Application No: LY/8/20/HH
Site Address: Pauls House 254 Church Lane Lyminster BN17 7QJ
Description of works: Replace existing roof, repair and repoint chimneys & insert a new dormer window on rear elevation. This application may affect the character & appearance of the Lyminster Conservation Area & may affect the setting of a Listed Building.

OWPC28369

ELEVATIONS AS PROPOSED 1:100

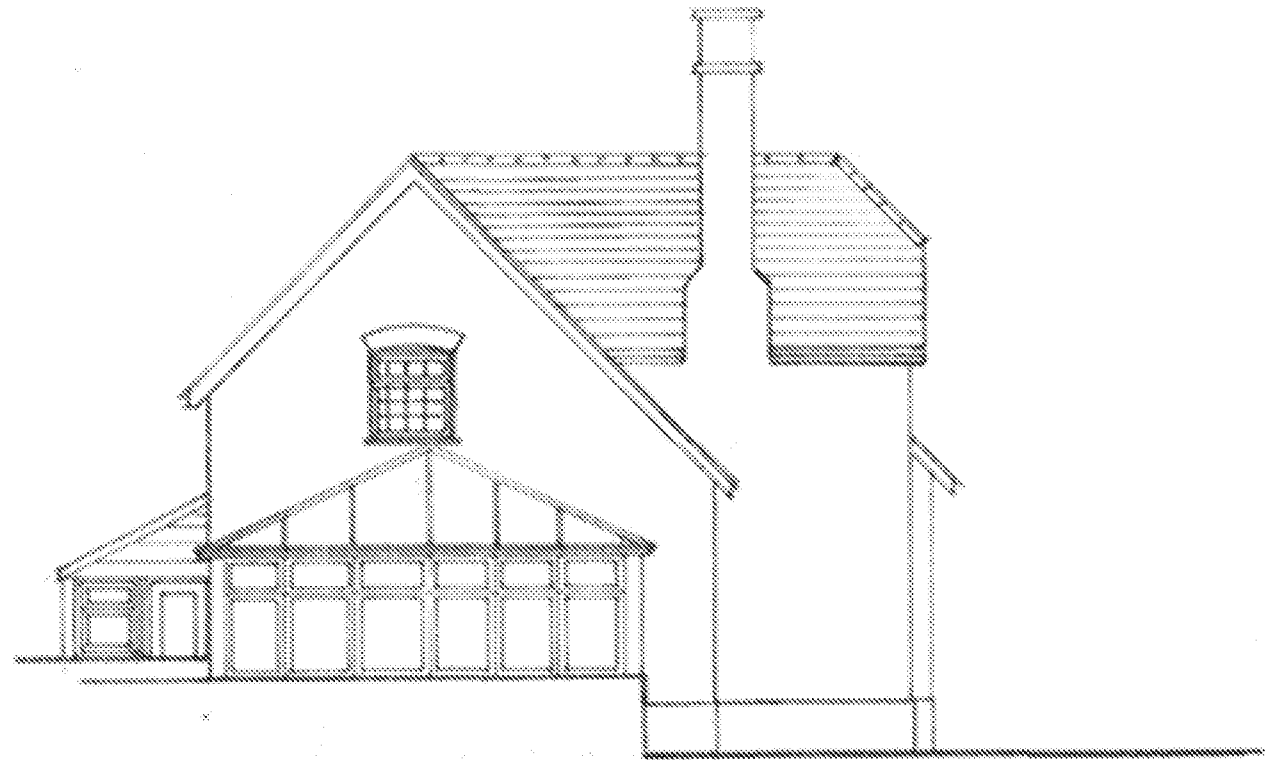
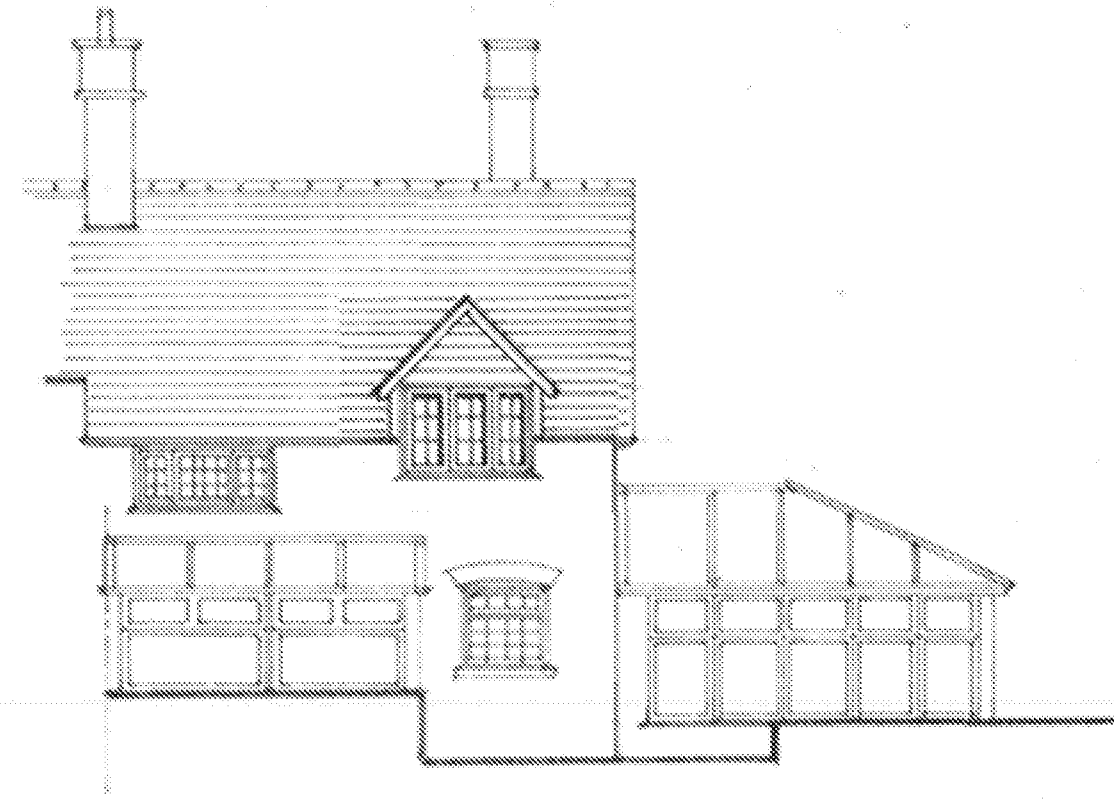
The proposed dormer window on the rear elevation is of an appropriate scale and design. If carried out to historic building standards all the proposed works will not impact adversely on the building or the conservation area.

The works of repair probably fall outside of planning control but care will be needed in the selection of any new plain clay roof tiles. Given the prominence of the chimney stacks and the quality of their design very special care will also be needed in respect of their repair and the appropriateness any new pointing.
